From: [Borough Planning](#)
To: ["neil@nkfplanning.co.uk"](mailto:neil@nkfplanning.co.uk)
Cc: [PScan1](#)
Subject: FW: Invalid Letter 22/00345/F
Date: 21 March 2022 13:36:48
Attachments:

Many thanks for your call earlier, as per our discussion site level plans are acceptable however please correct elevation title on plans.

Previous Side Elevation 1:100

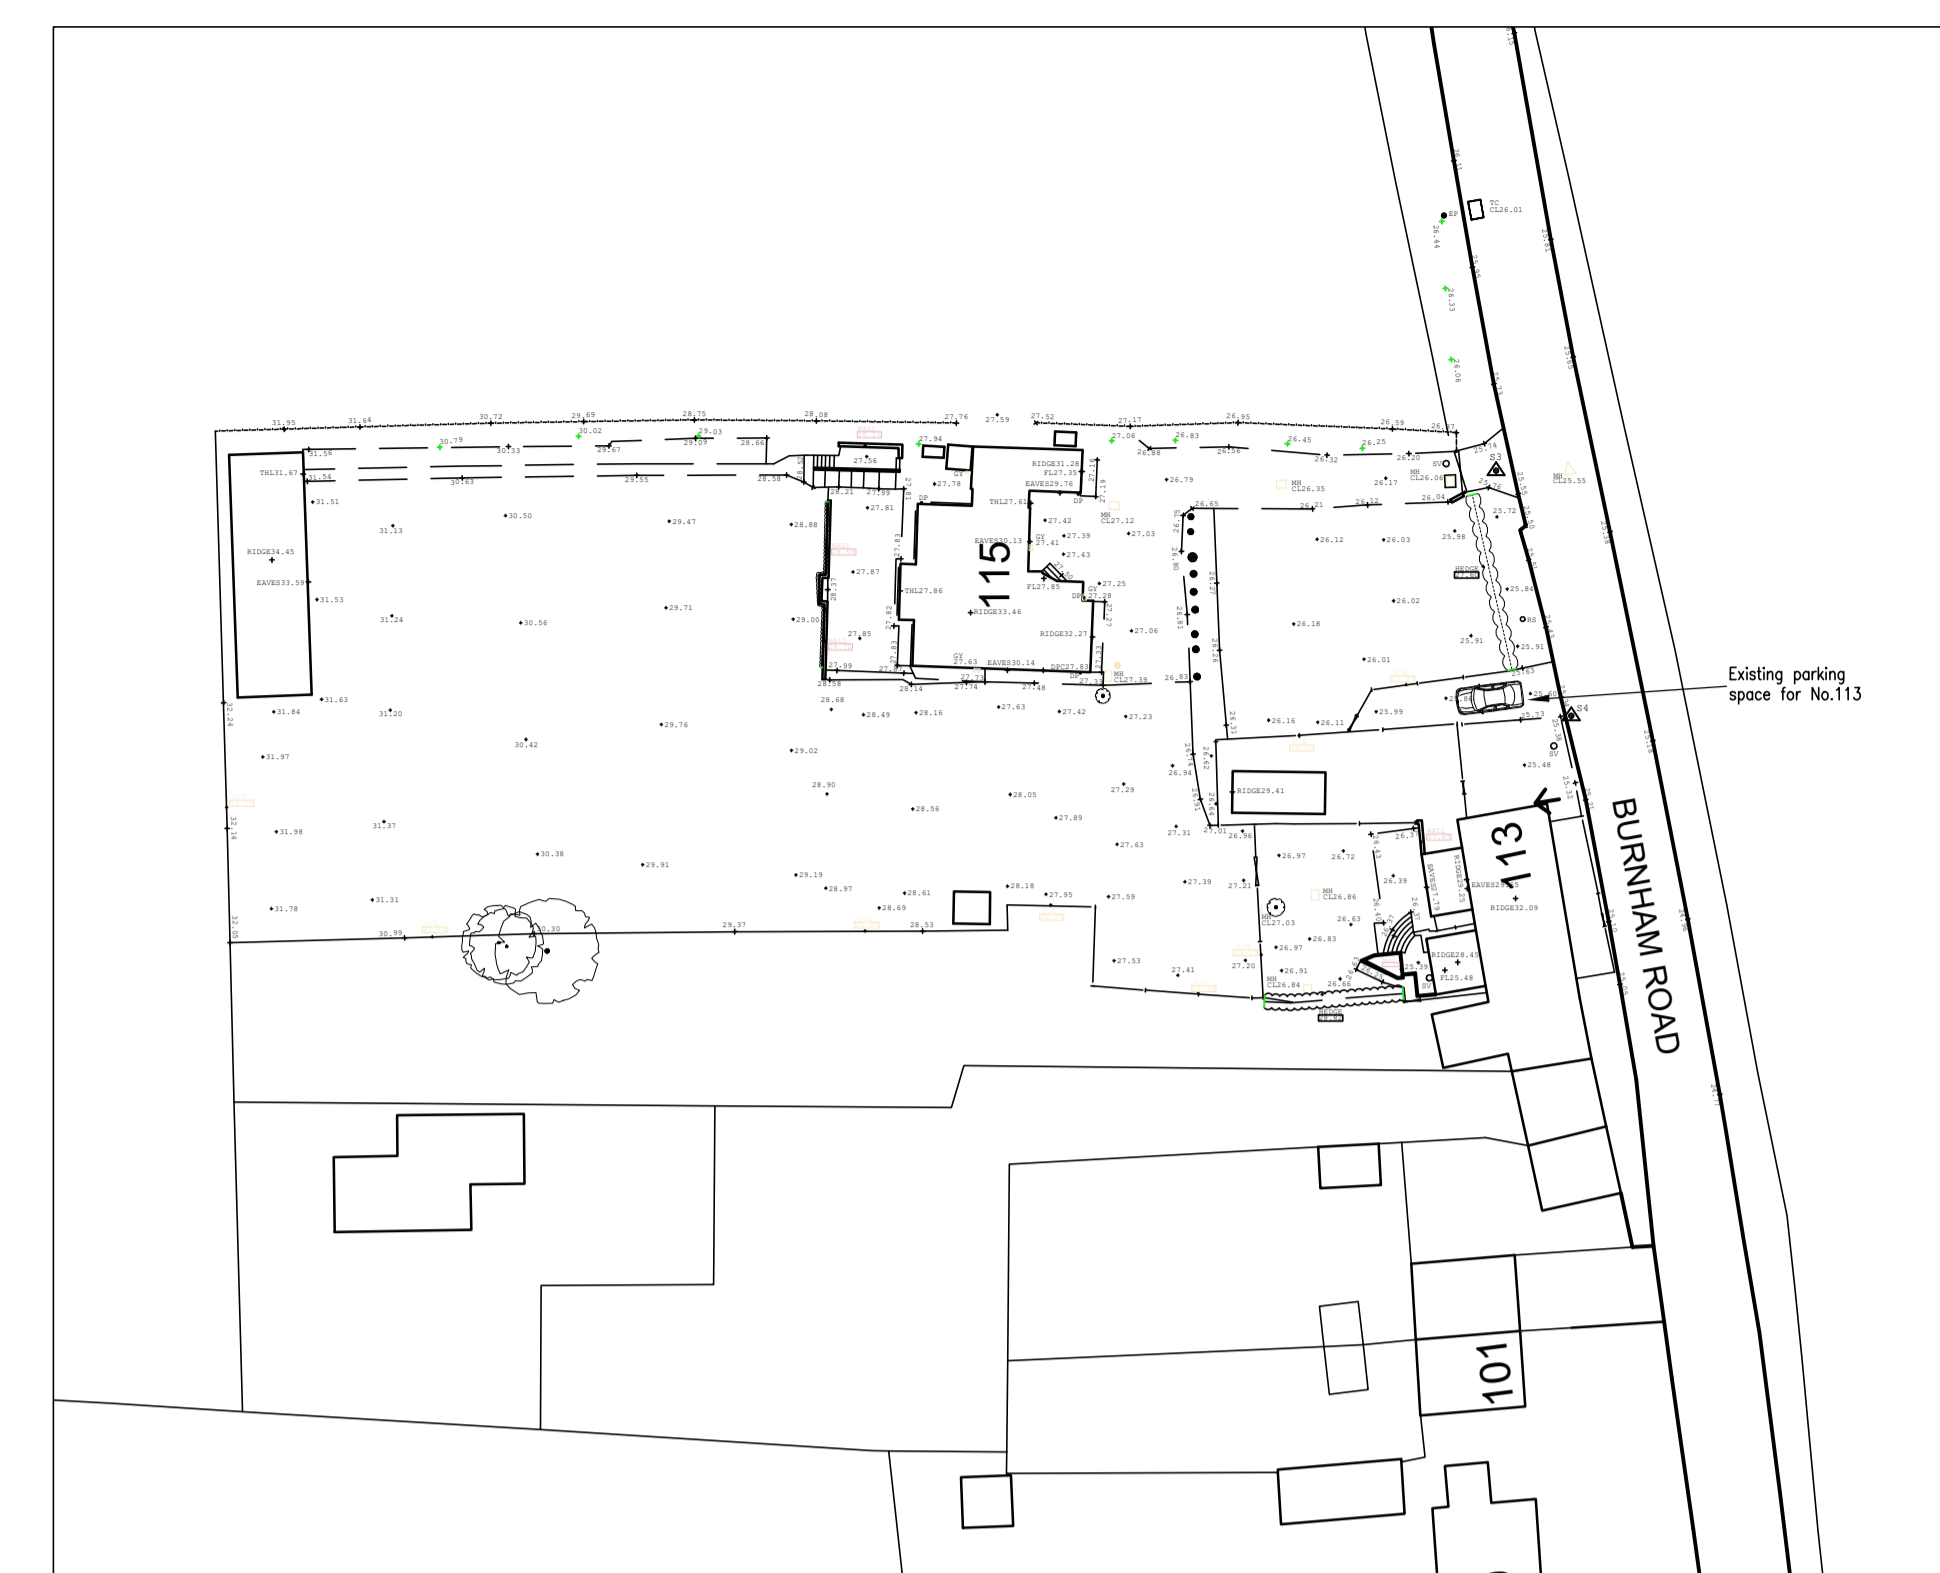
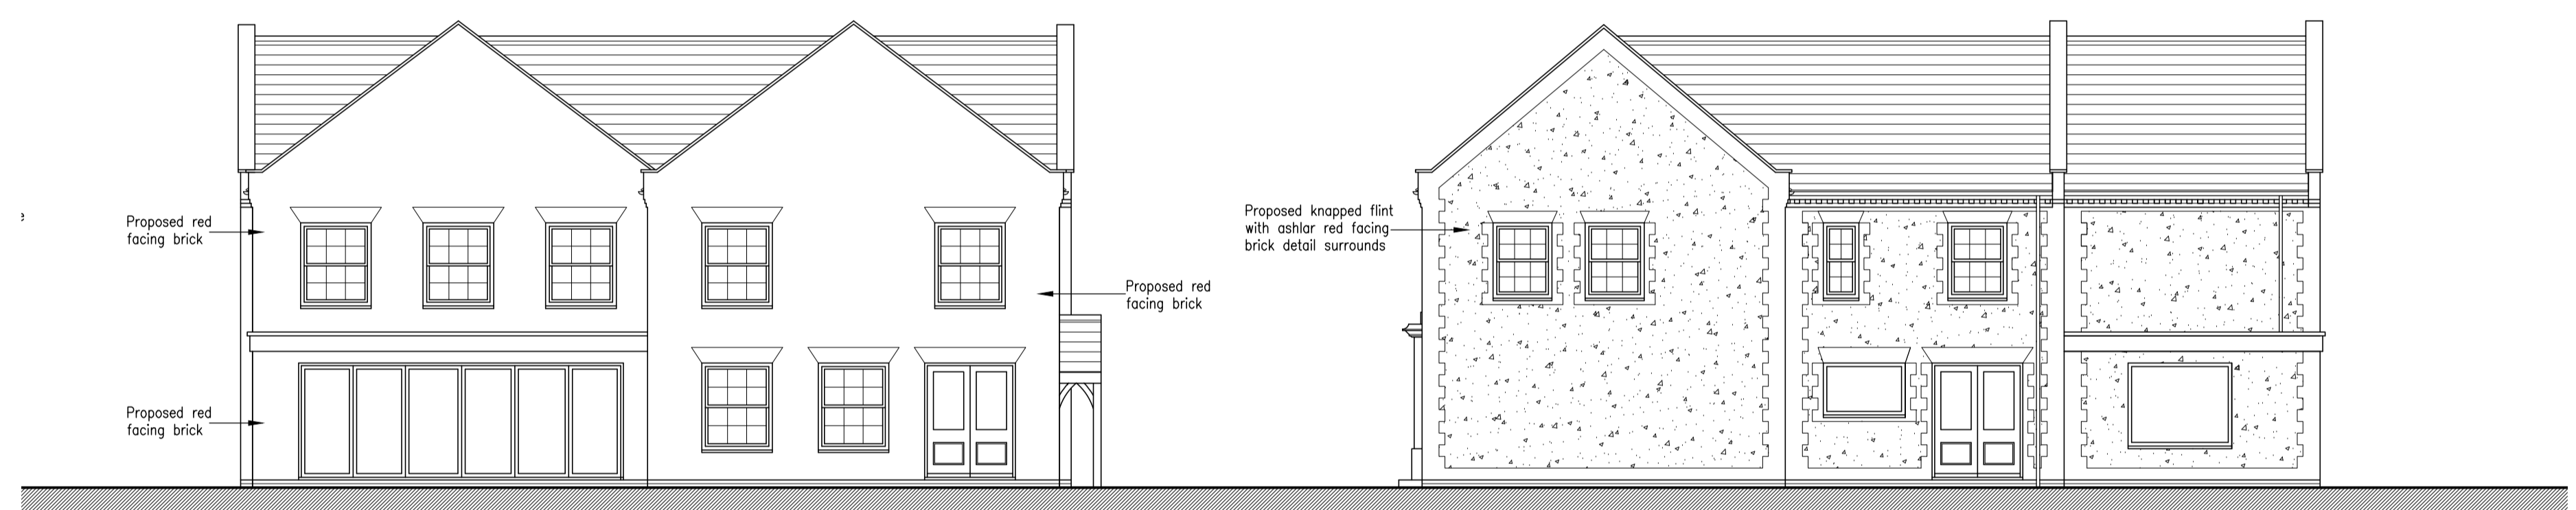
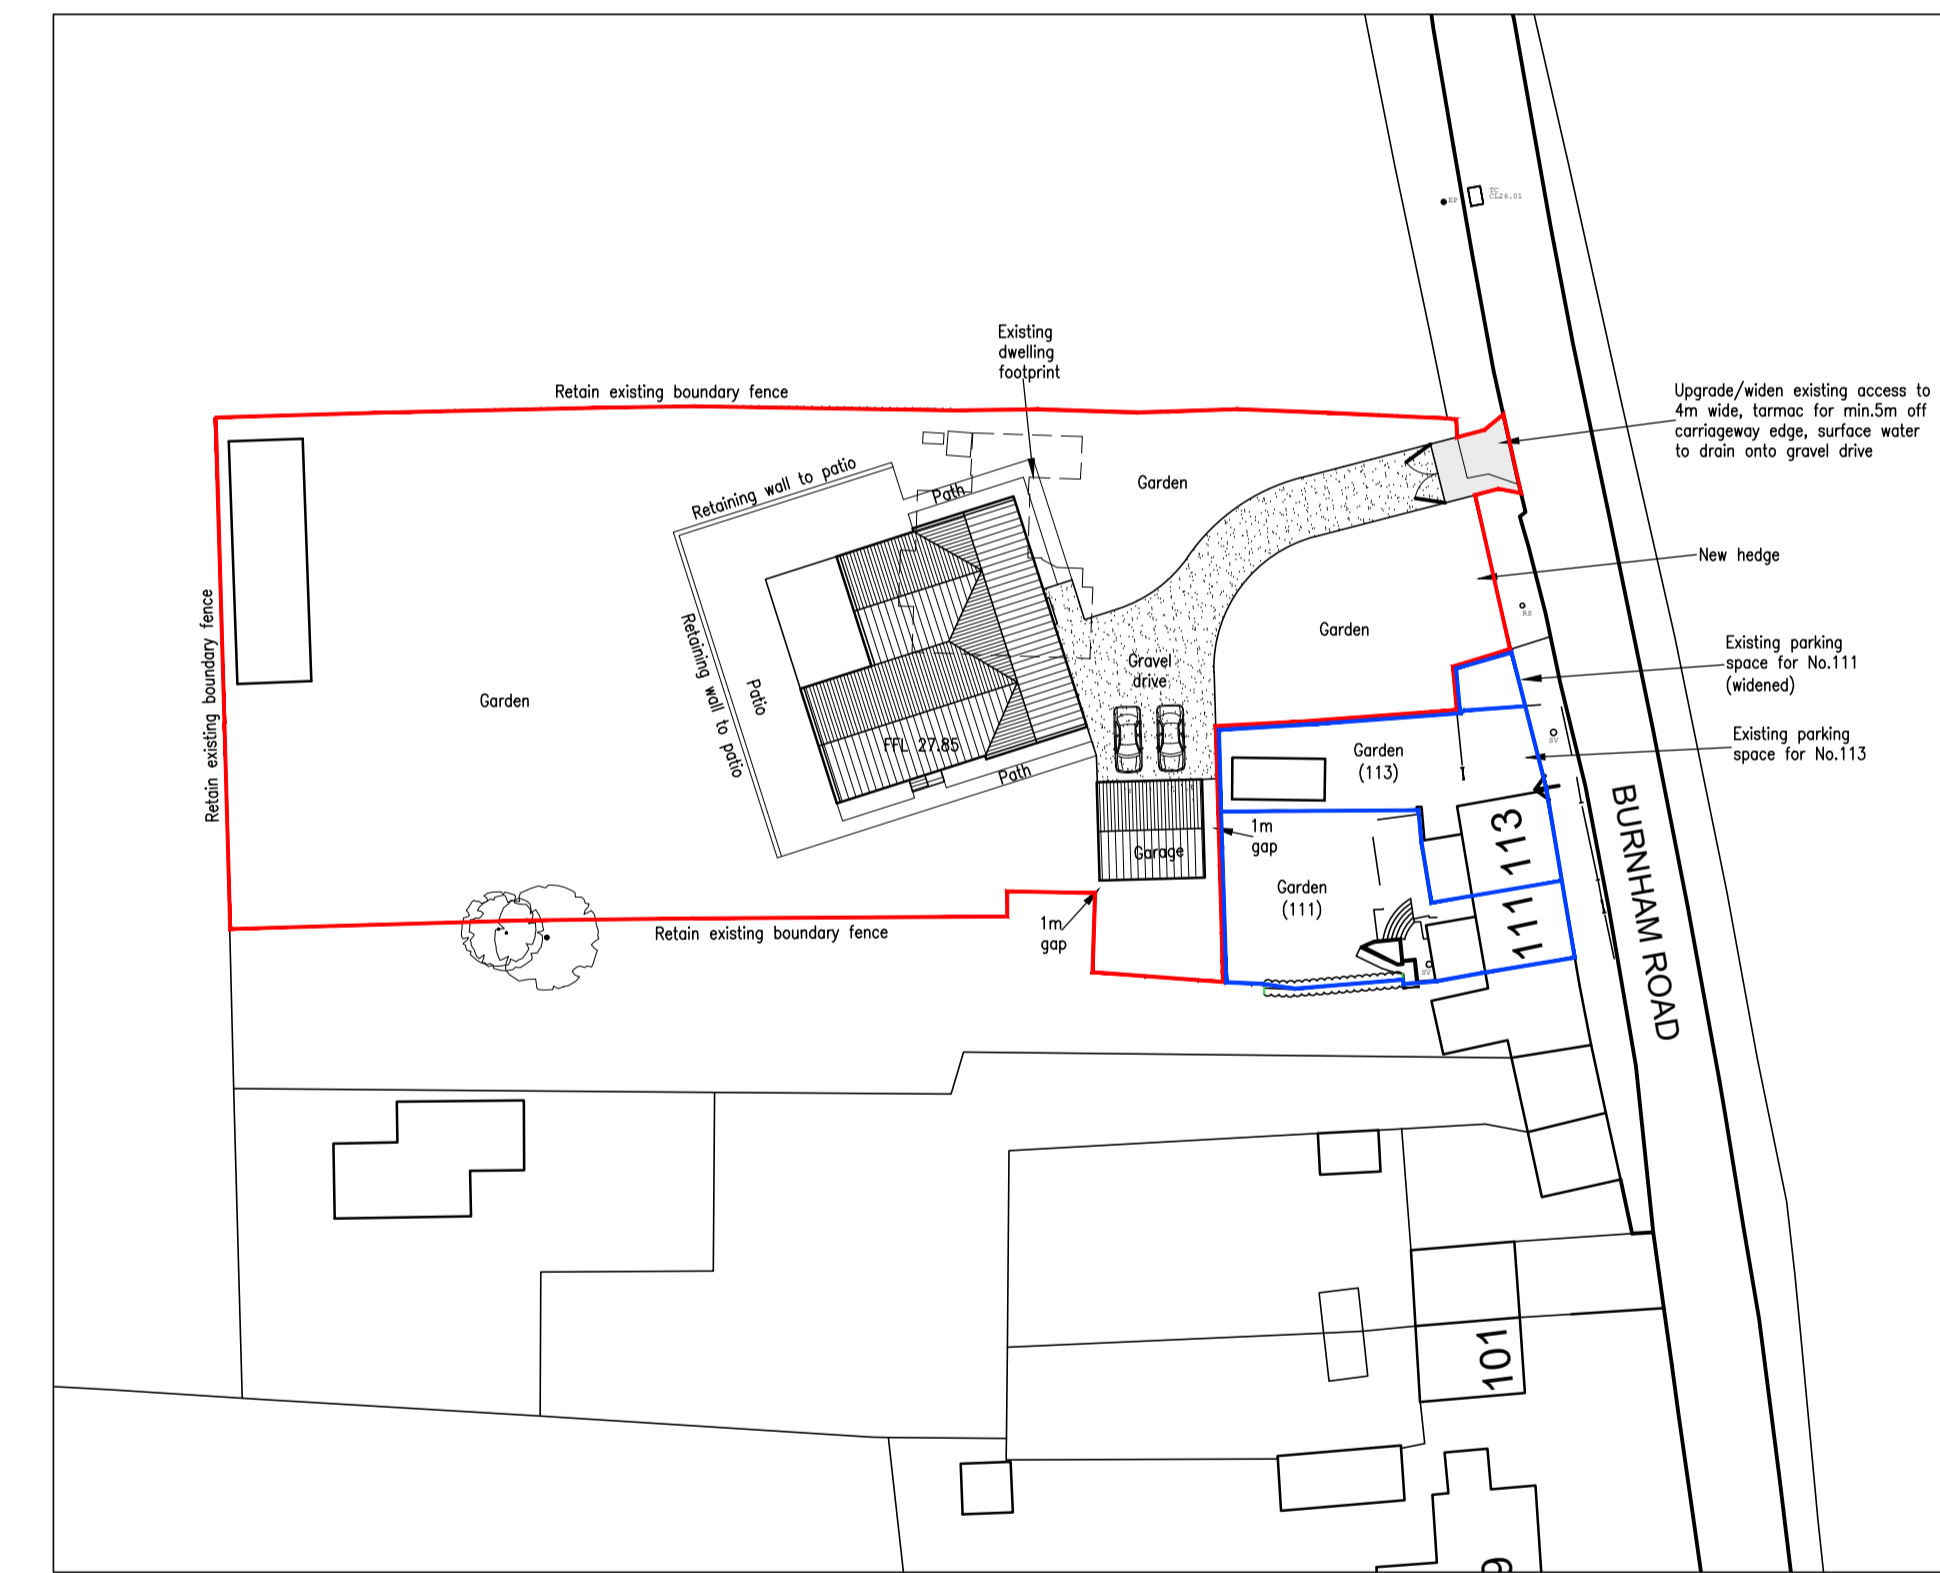
We will ask the architect to amend the existing site plan description to say existing and proposed site plan. However, I am not sure what your question is in relation to:

Please confirm what are you trying to show with "Previous Side Elevations"?
